## ABP ORAL HEARING METROLINK 314724

This oral submission specifically focuses on my submission referenced 27 and the TII response to it. I regard this response as inadequate as outlined below. I am also authorised by MetroSouthWest in the interest of avoiding duplication to cover the issue of bus connectivity raised in their submission referenced 189 .

Charlemont LUAS stairs & lift connection 2024

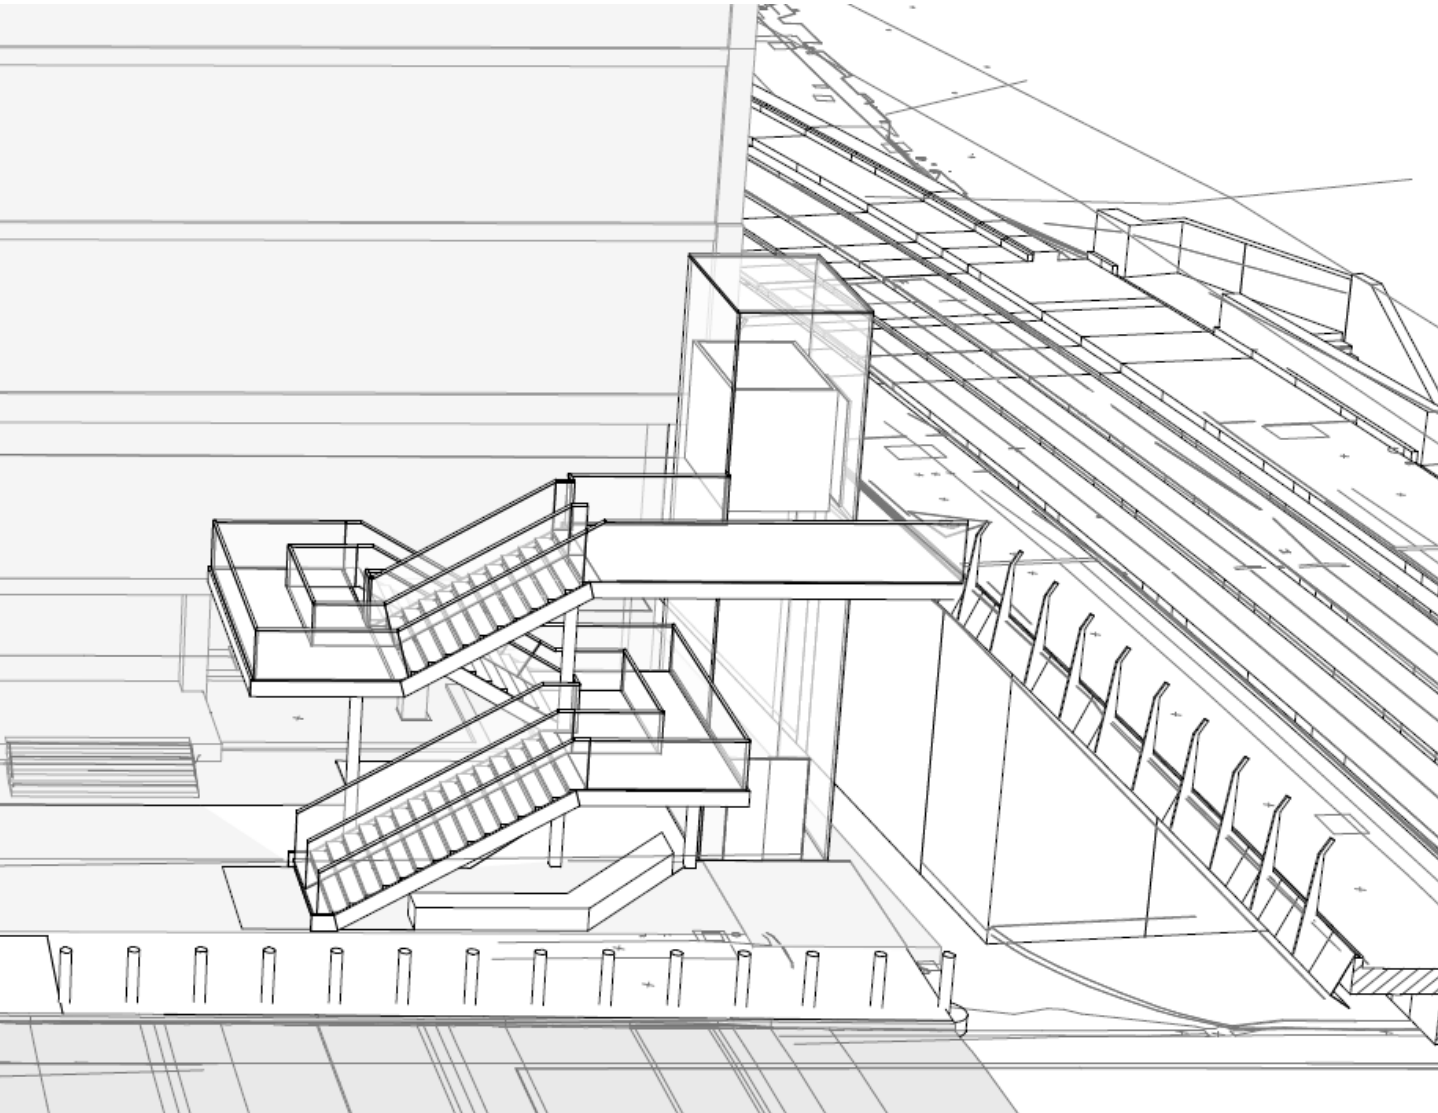
1 excessive pressure on two Luas stairs respectively 2.4 and 2 metres wide to deal with all the Luas transfer passengers in both directions

2 that the southbound Luas platform which measures about 2.85 metres by 40 metres is inadequate to cope with the likely southbound traffic.

On all of the TII forecasts there will be a huge volume of passengers coming to and from the Luas to metro and they will all be funnelled into two Luas stairs. It seems bizarre to funnel so many passengers into such a limited infrastructure. Particularly if they are likely to be walking in different directions to and from the Luas. I do not accept that a 2.4 metre wide stair is properly "sized to accommodate the combined predicted passenger flows for Luas to Metro and Metro to Luas" (page 161 of response Part 1).

I believe the effectively usable area of the southbound platform probably accommodates at best 100 passengers. I think routinely this will be exceeded. There are already many passengers feeding into this platform from the north side of the Grand Canal (over 2,500 suggested in day 13 document). The use of this platform as a bridge as Fred and Frida did in my submission will complicate the issue.

I believe that people climbing the new stairs will clog the southbound platform at the end of the stairs. This happens all the time in the London Underground. I don't think it is correct to assert that "peak passenger demand profiles for each station have informed the layout and sizing of platforms and stations" (page 161 response document) when my criticism is aimed at Charlemont Luas.

I don't agree that it was not possible to fit escalators linking ground level to the Luas, but the Bord has permitted development of the site in a way that makes this very difficult. Any sensible interconnection should have at least two escalators between ground level and Luas to match what emerges from the Metrolink (three per their response) . Escalators obviously also prevent two way traffic, bar the odd group of 15 year olds.

It is common that stairs (for example London Underground, New York Subway) indicate that people should keep left. However this is not generally obeyed and on a 2.4 metre wide stair conflict between ascending and descending passengers will be routine.

There will be a single additional lift apparently accommodating 10. 10 capacity is likely reduced by wheelchairs and/or luggage. I do not agree that this is "again sized for the predicted passenger

flows, for persons of restricted mobility and so that people are not having to carry luggage of a size that should not be carried on the stairs" (page 161 of response), given that it is the end of a line coming from the airport.
